From: Breezie Allwright <Breezie.Allwright@arun.gov.uk>
Sent: 26 January 2026 08:21
To: Planning.Responses <Planning.Responses@arun.gov.uk>
Subject: Fw: R/215/25/HH

HUGE EXTENSIONS PLANS FROM MR MRS THOMAS'S SHOWS THAT MY HOME NO 1 EVELYN WOULD HAVE ROOF TILES EN MASSE DIRECTLY IN FRONT OF MAIN LIVING ROOM GLASS WINDOWS, GLASS CONSERVATORY WE HAVE TREMENDOUSLY STRONG WINDS SO THIS COULD BE A DANGER TO OUR SAFETY .

Drawing:  
**Plans and elevations as proposed**

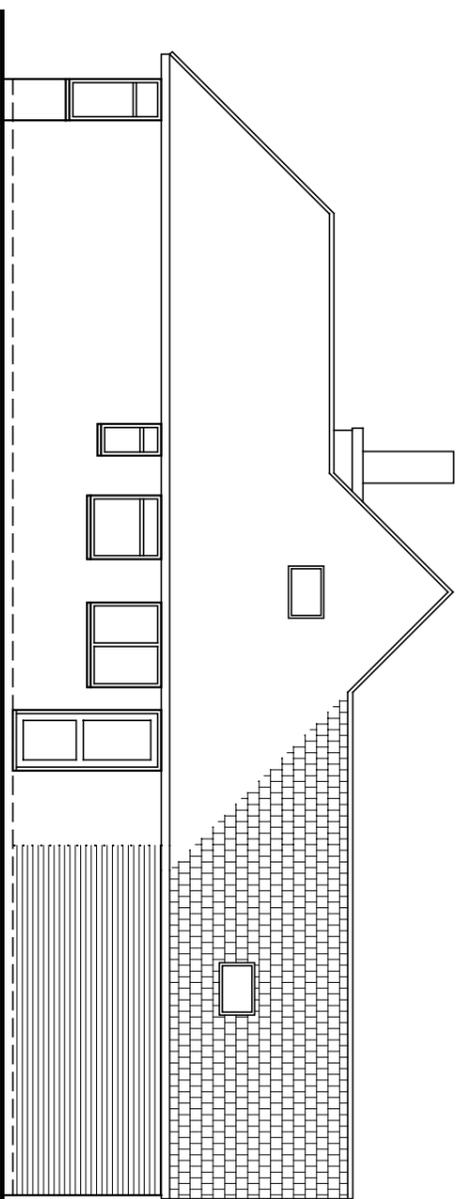
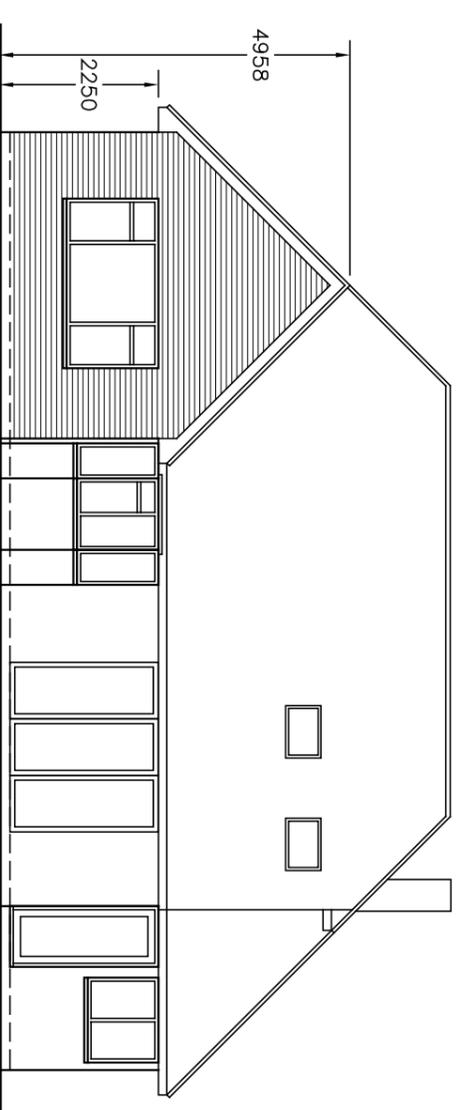
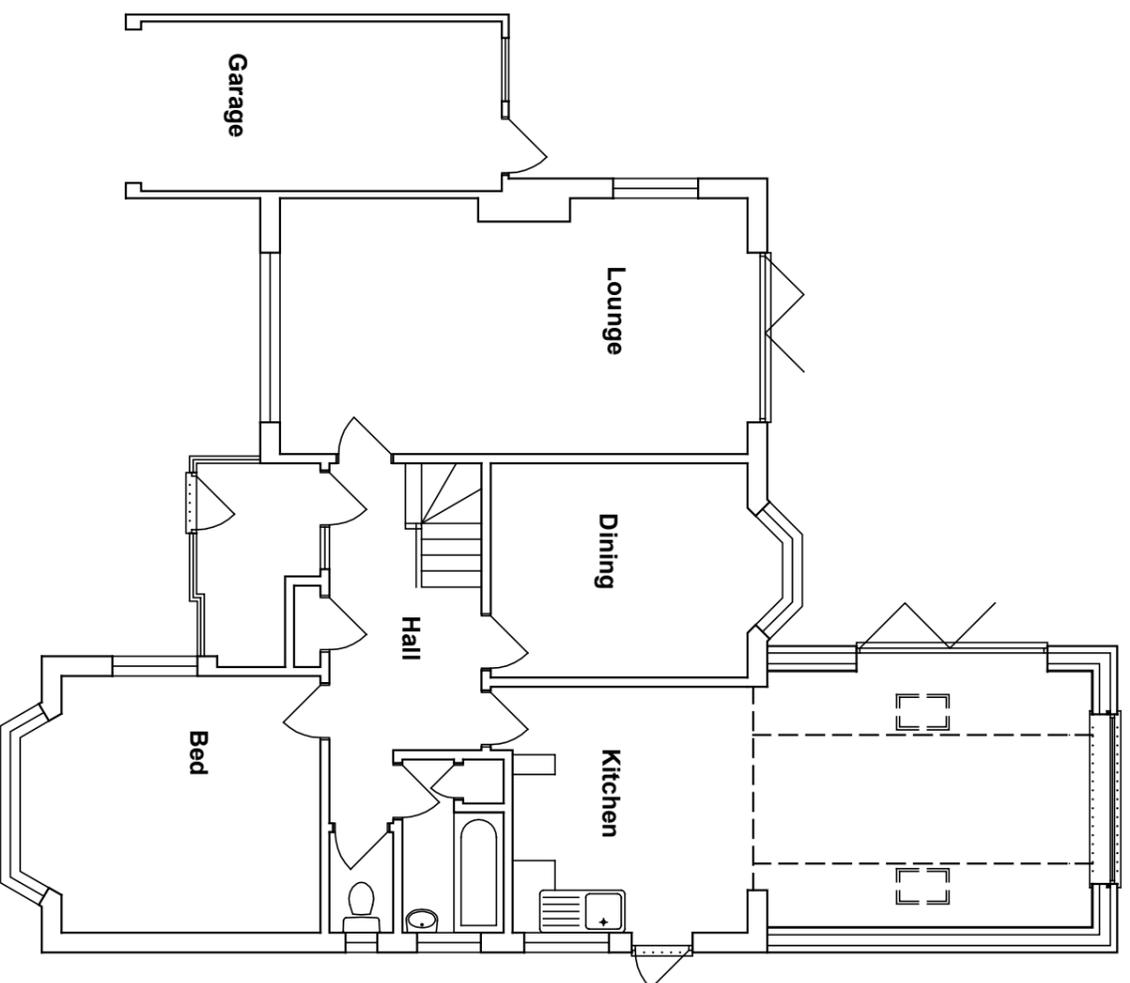
Proposed plans will leave "21 ft of brick wall and gutter " , running along my south border
view,
in my direct view from my home,
my south border outlook would be unsightly over shadowing overbearing ,intrusive unsightly

21 ft of wall on south facing border i fear will

planned extension will block sunlight to main living are and also conservatory,

my south border where light comes from is where thompsons plan to build ,wall and gutter will be high enough to make this occur
